Online Comment

Application H14-1081-23
Location Land north of Wardentree Lane Pinchbeck Spalding
Proposal Erection of 96 dwellings and associated works - approved under H14-0165-21. Modification of Condition 1 to allow amendments to previously approved plans and Condition 7 relating to tree protection/landscaping

Date Submitted 27-03-24
For/Against Objections

Drawing:
Planning Site Layout

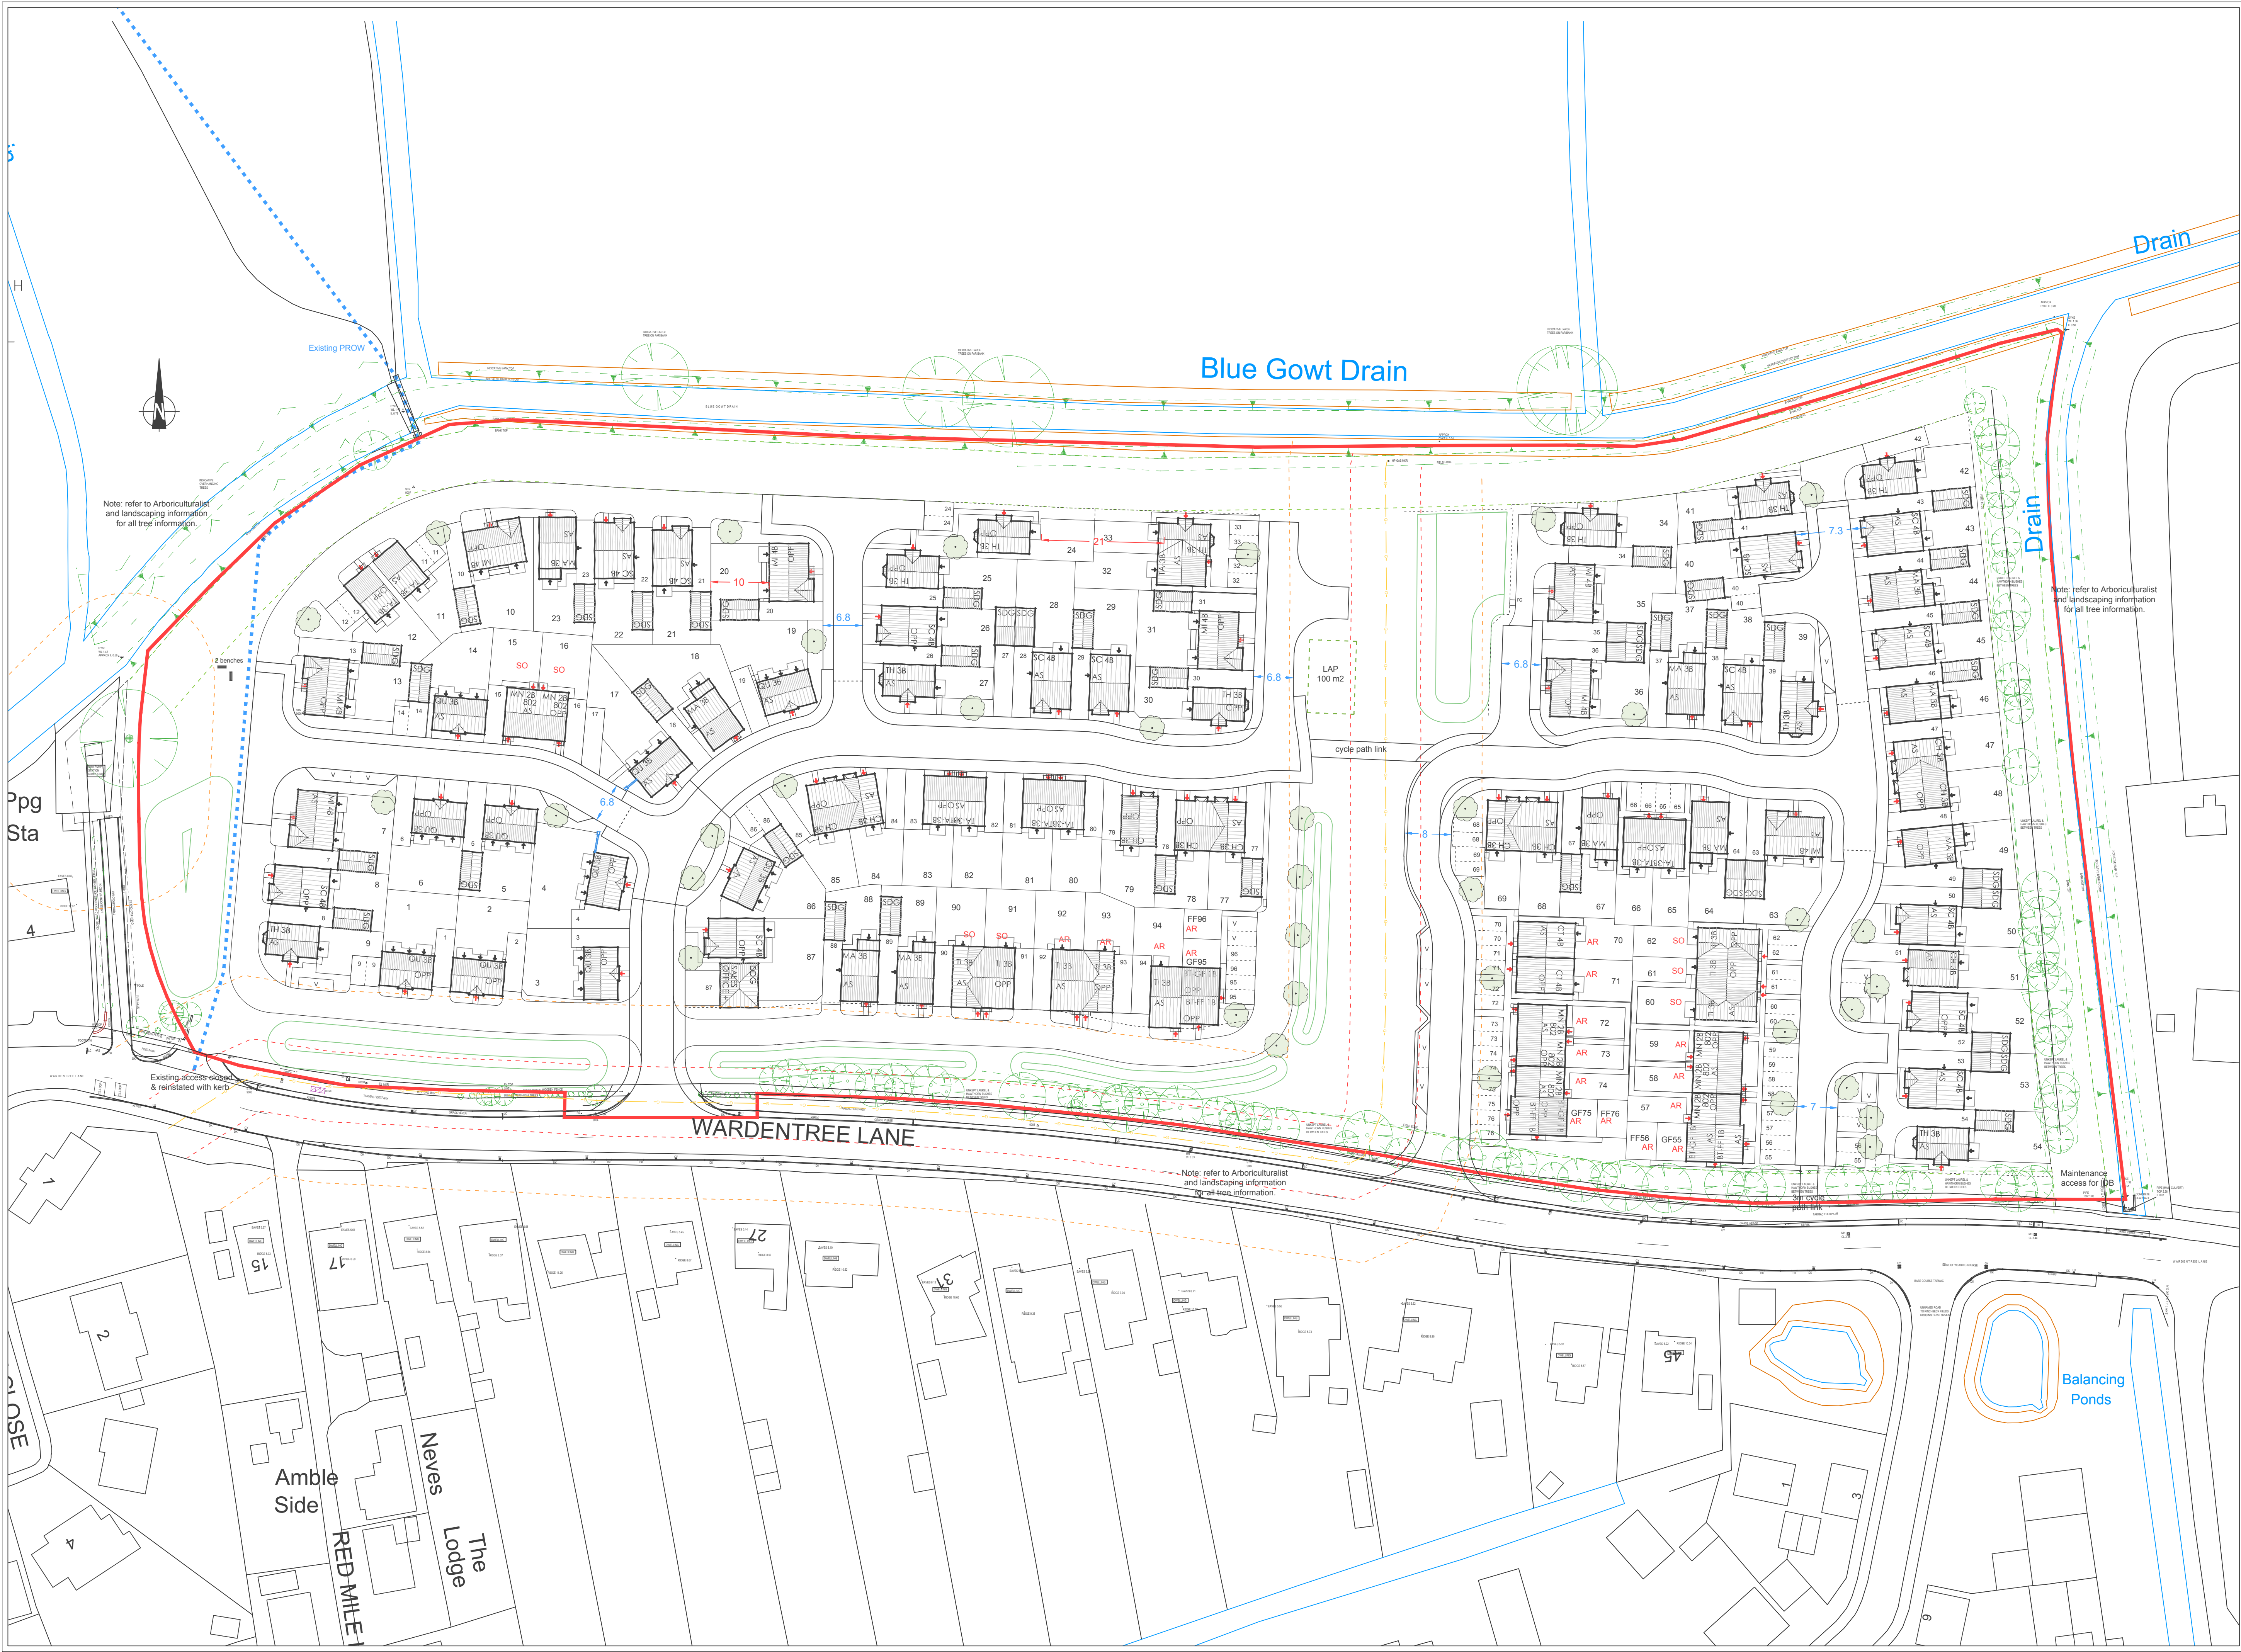
Lincolnshire County Council has been awarded funds for the improvement of the cycling infrastructure connecting Pinchbeck with Spalding. We understand that the cycle path on the north side of Wardentree Lane will form part of the improved route. To approve the proposed additional vehicle access will be contrary to the aims of that investment and the principles set out in Table 10-1 of Cycle Infrastructure Design (Department for Transport Local Transport Note 1/20). Please ask Lincolnshire County Council for its specific observations on this matter.

The detailed design, road markings and signage of the junction already approved and the proposed junction, if it is approved despite our objection, should give cyclists using the cycle path the same priority over the side road as is enjoyed by all users of Wardentree Lane's vehicle carriageway.
